Please ask for: Nicola Moore
Email: nicola.moore@arun.gov.uk
Telephone: Ext 37944
Our Ref: EP/131/21/CLP
Your Ref:
Date: 14th October 2021

Lawful Development Certificate for a Proposed Use or Development

Development: Lawful development certificate for the proposed construction of single storey rear extension.
Location: 18 Clarence Drive East Preston BN16 1EH

PROPOSED SITE PLAN  
scale 1:200

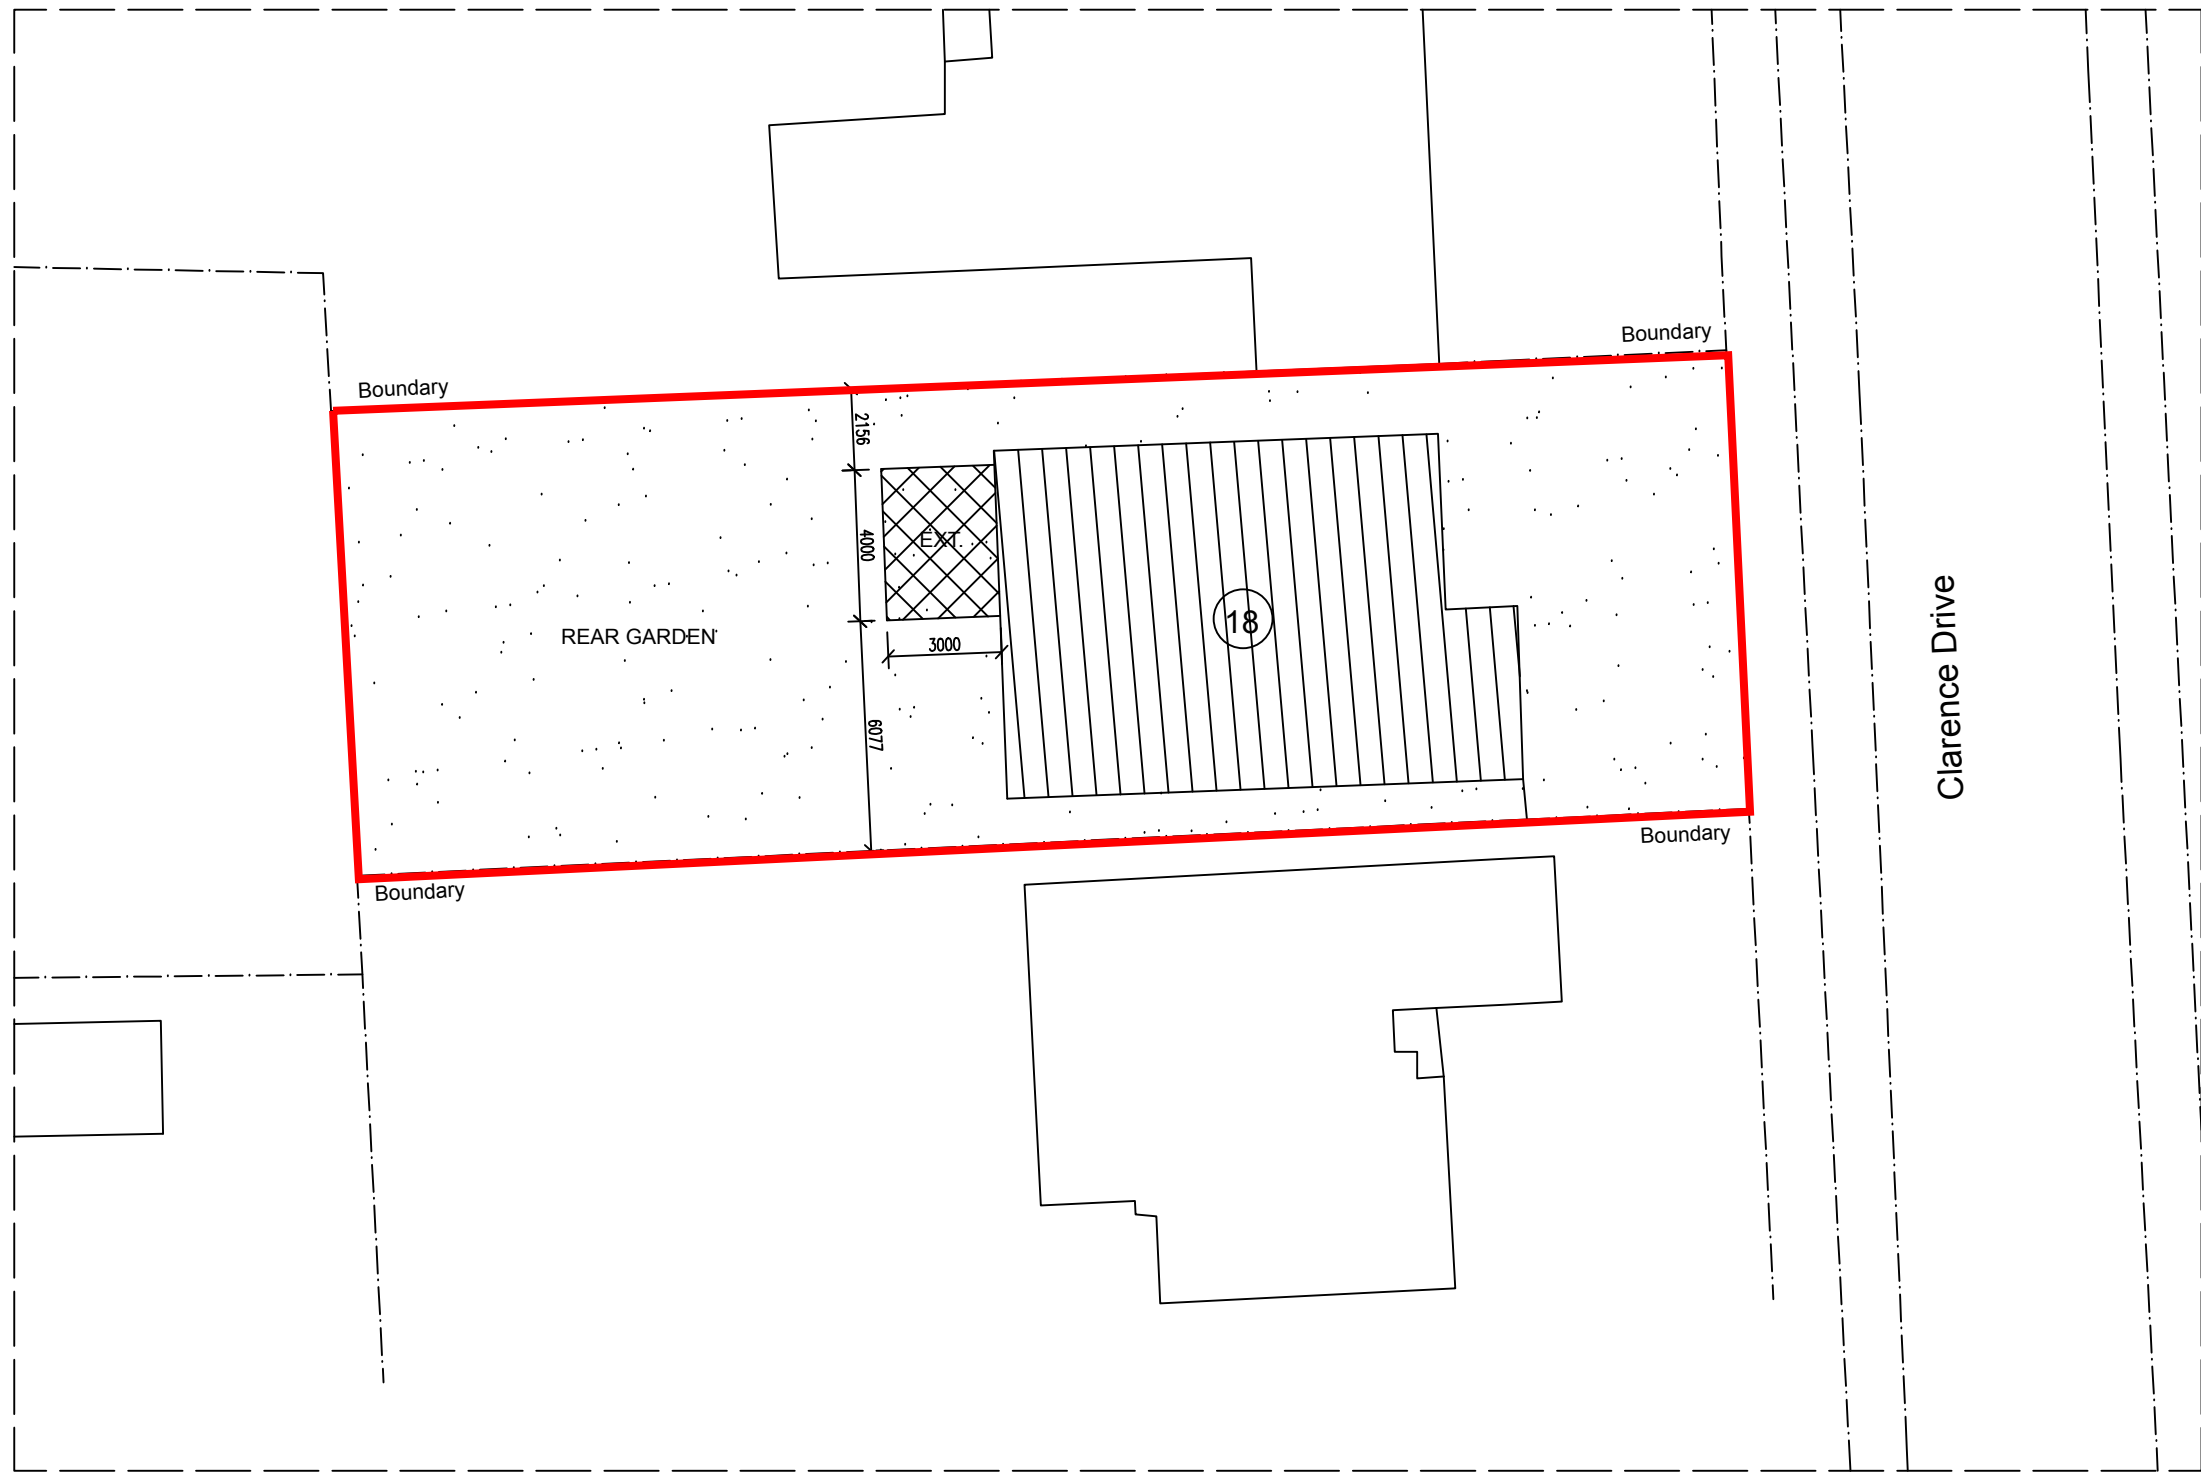
Block Plan

Please amend the Block plan to include dimensions to boundaries from the proposed development and re submit. Further details of what must be included on the plan can be found in the Validation Requirements List.
